CHENNAI METROPOLITAN DEVELOPMENT AUTHORITY

File No. : CMDA/PP/NHRB/C/0281/2020

Sub : CMDA-Area plans Unit - 'B' Channel (Central) – The Planning Permission application received for the Proposed construction of Stilt+3 floors Residential building with 39 dwelling units at Plot No.1, Vinayagam Avenue, Kundrathur, Chennai comprised in S.No.1378/8 of Kundathur village within limit of Kundrathur TP Particulars called for - Reg

Violations / defects in Plan Scrutiny:

**DESIGN OF SEPTIC TANK WITH TWO UP FLOW FILTERS.**

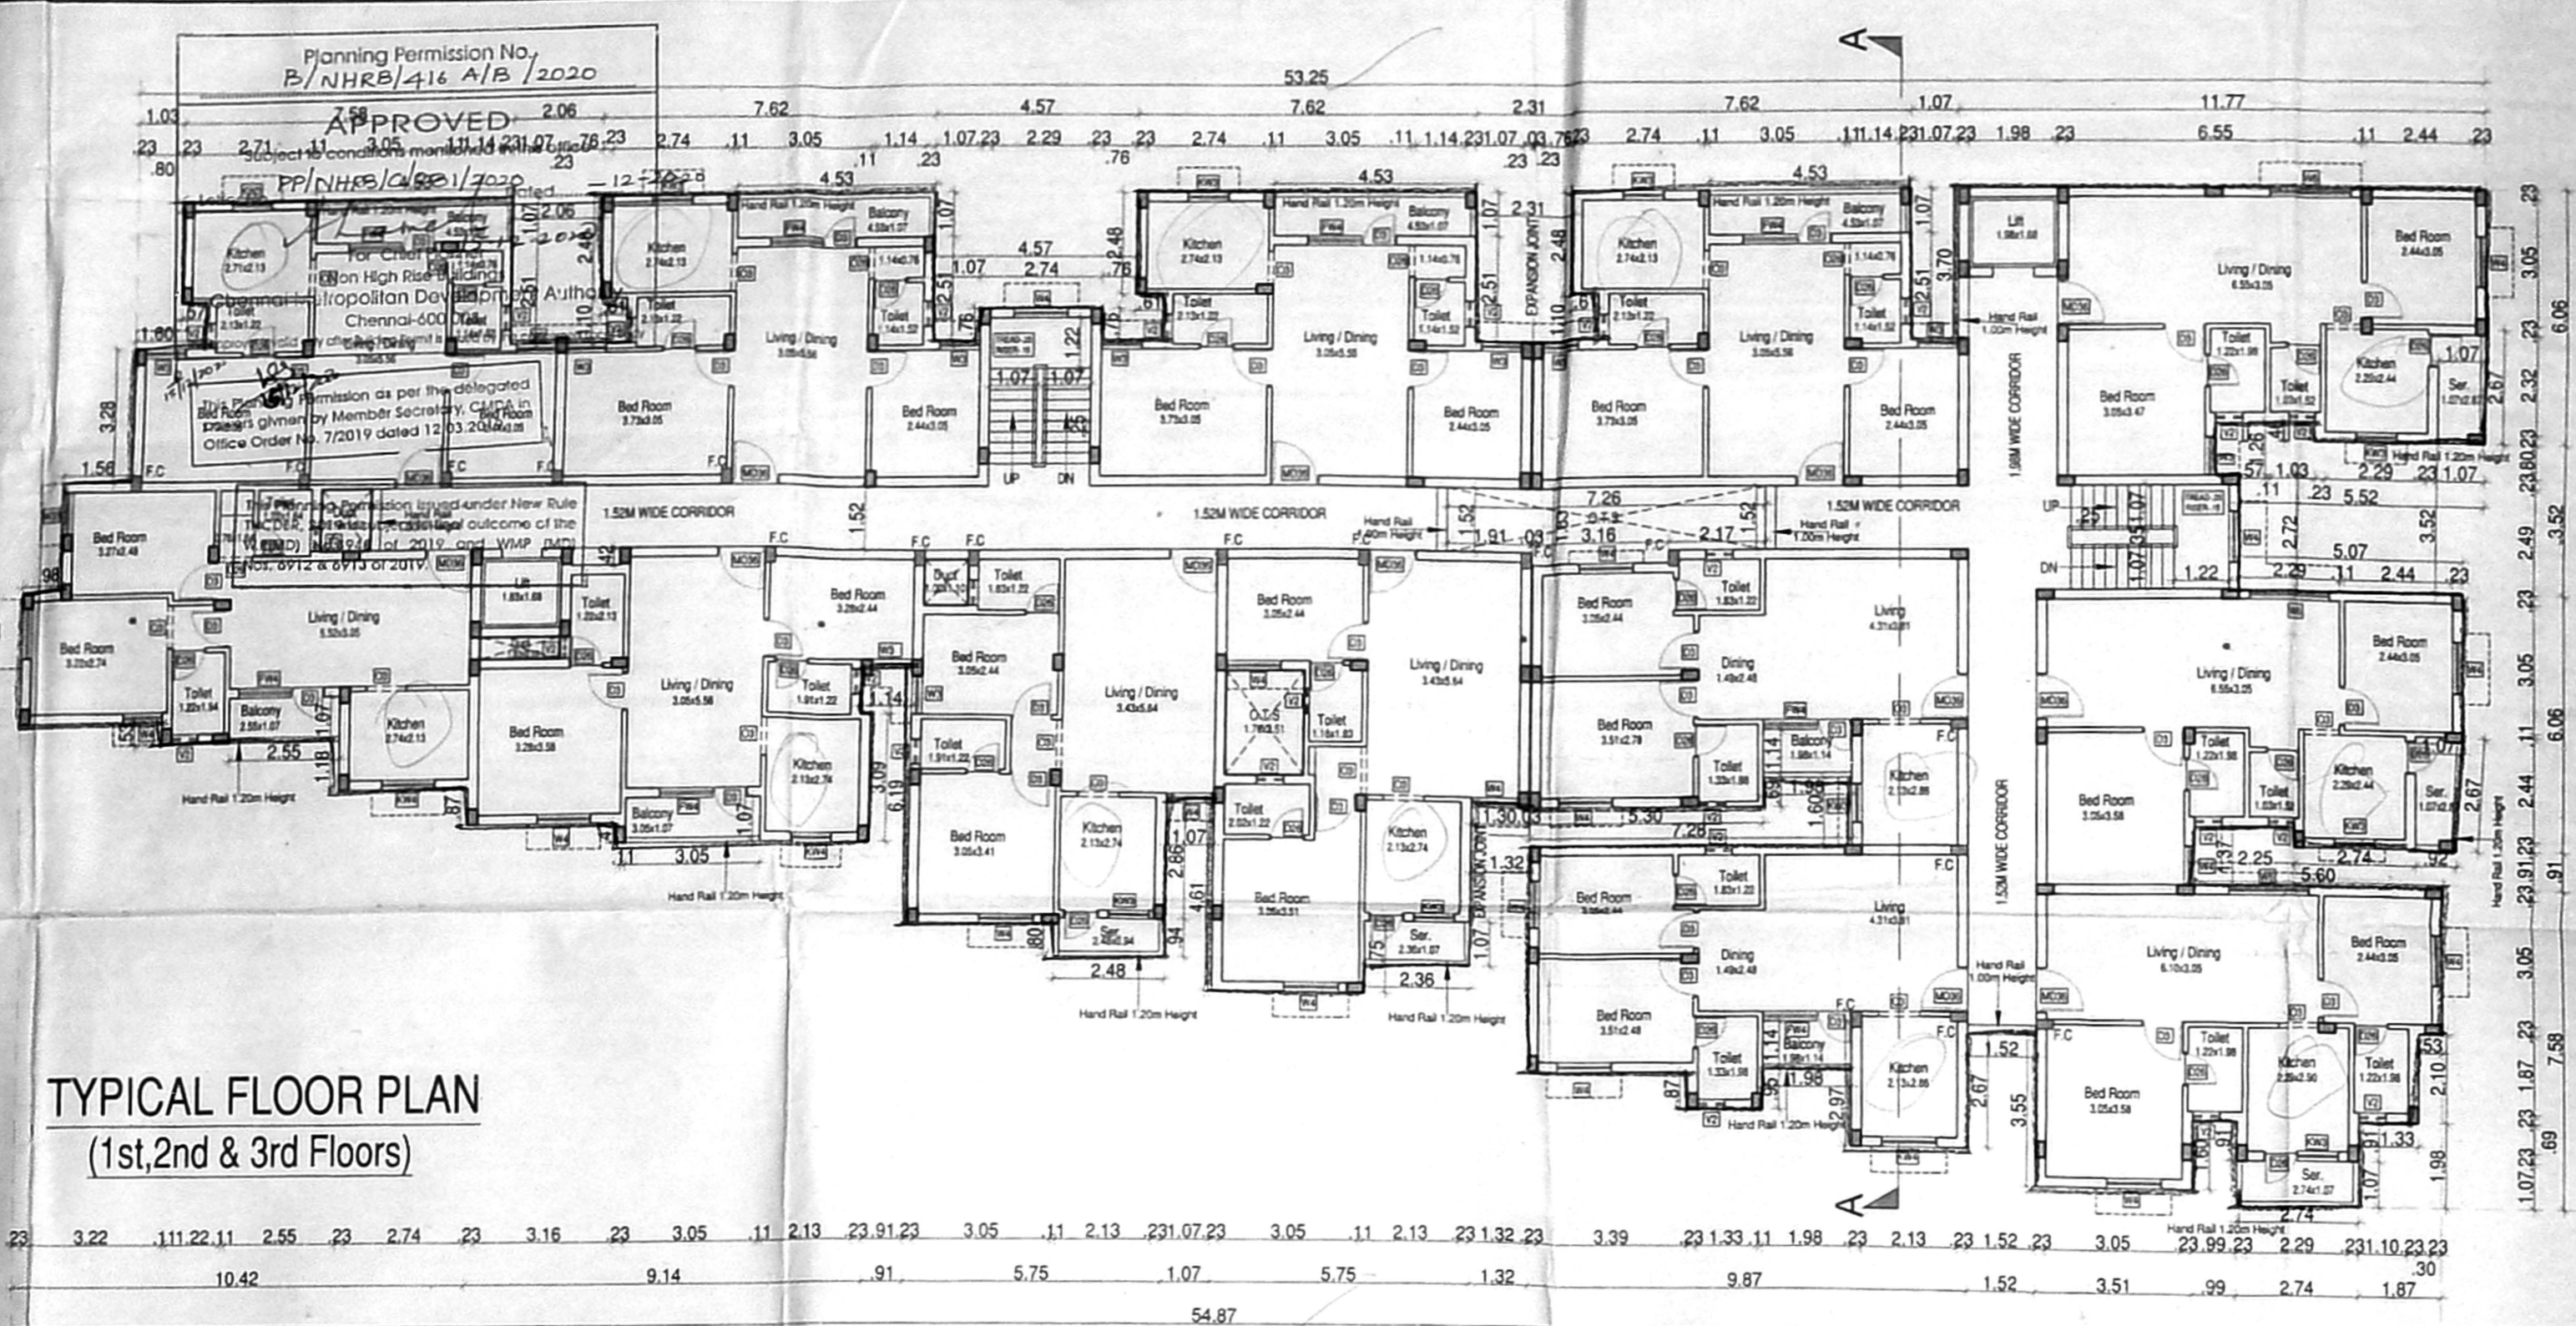
- 1.Title and Area statement to be shown correctly.
- 2.Section and Elevation to be shown correctly.
- 3.Setback details to be shown correctly.
- 4.As on site and As per FMB to be shown correctly and difference to be shown on the rear side. (should not be show along road side).
- 5.Set Back measurements to be shown from the least boundary measurement line.
- 6.Individual FMB incorporating plot extent and measurements attested by revenue official not below the rank of Dept Tahsilar to be furnished.
- 7.4.50m Aisle width to be provided for perpendicular car parking , Hence all the Car parking to be rearranged.
- 8.Septic Tank with upflow filter along with design calculation to be shown in the plan.
